Government and Public Submissions in Full

DOC17/508941-4
06_0310 MOD 2

Emirates One&Only Wolgan Valley 06_0310 MOD 2

Notice of s.75W Modification Request for Emirates Luxury Resort (now known as Emirates One&Only Wolgan Valley), 2600 Wolgan Valley Road, Wolgan Valley, Lithgow LGA MP 05_0079 MOD 2 (Concept Plan) and MP 06_0310 MOD 2 (Project Approval)

Figure 2: Existing and proposed helipad locations and proposed bee hives location

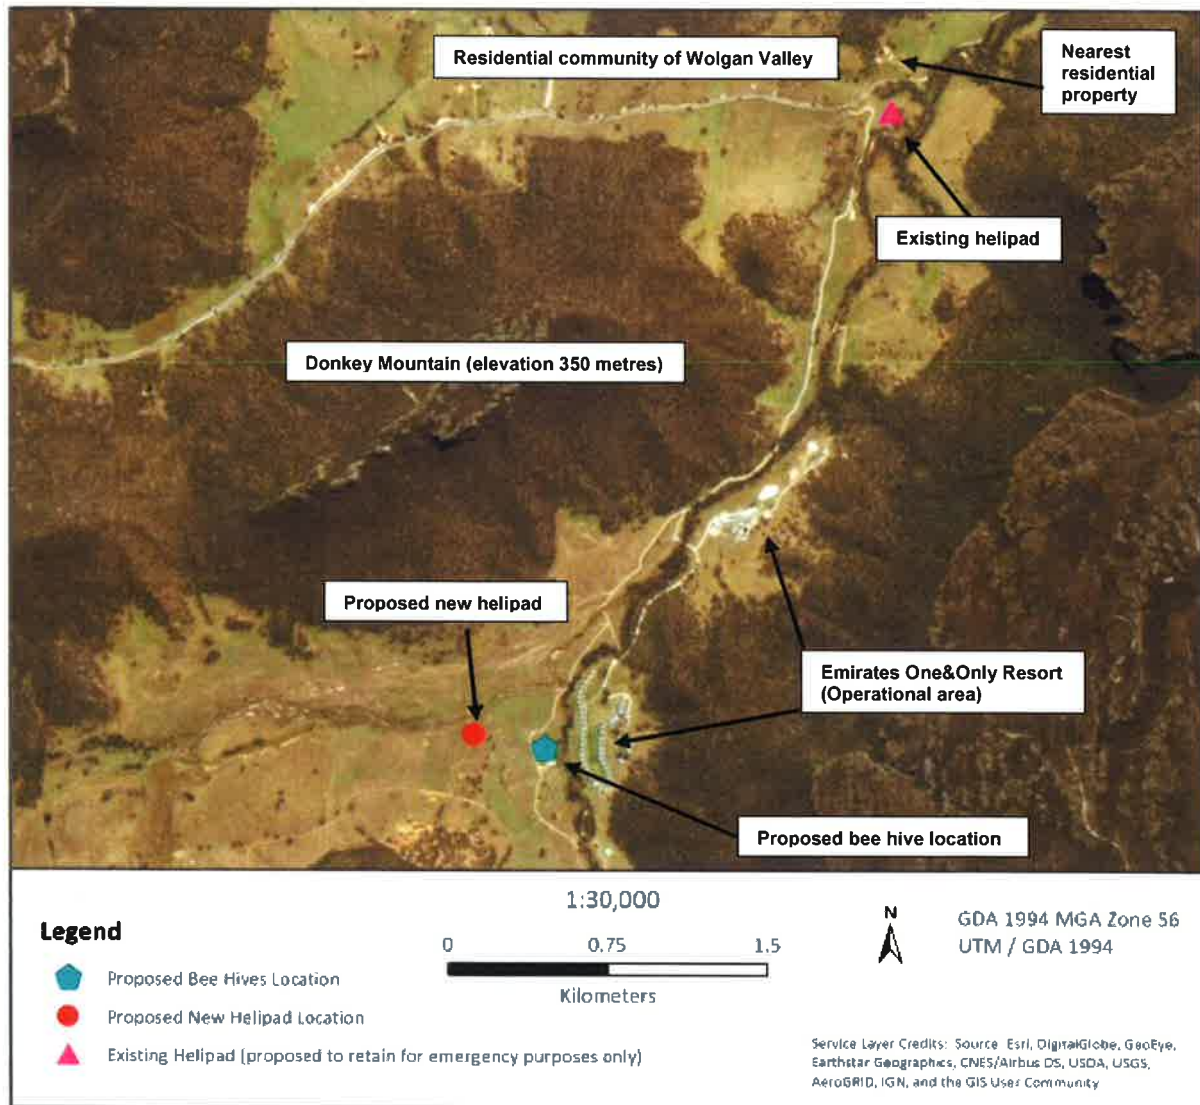
OEH recommends that the proponent provide information specific to the new proposed helipad site regarding the flora species that are present and the condition state of the vegetation.

If the proponent provides information to confirm that the vegetation at the proposed helipad site is non-native, then given the negligible impact of the proposed activity on biodiversity values this project modification should not require a biodiversity offset strategy.
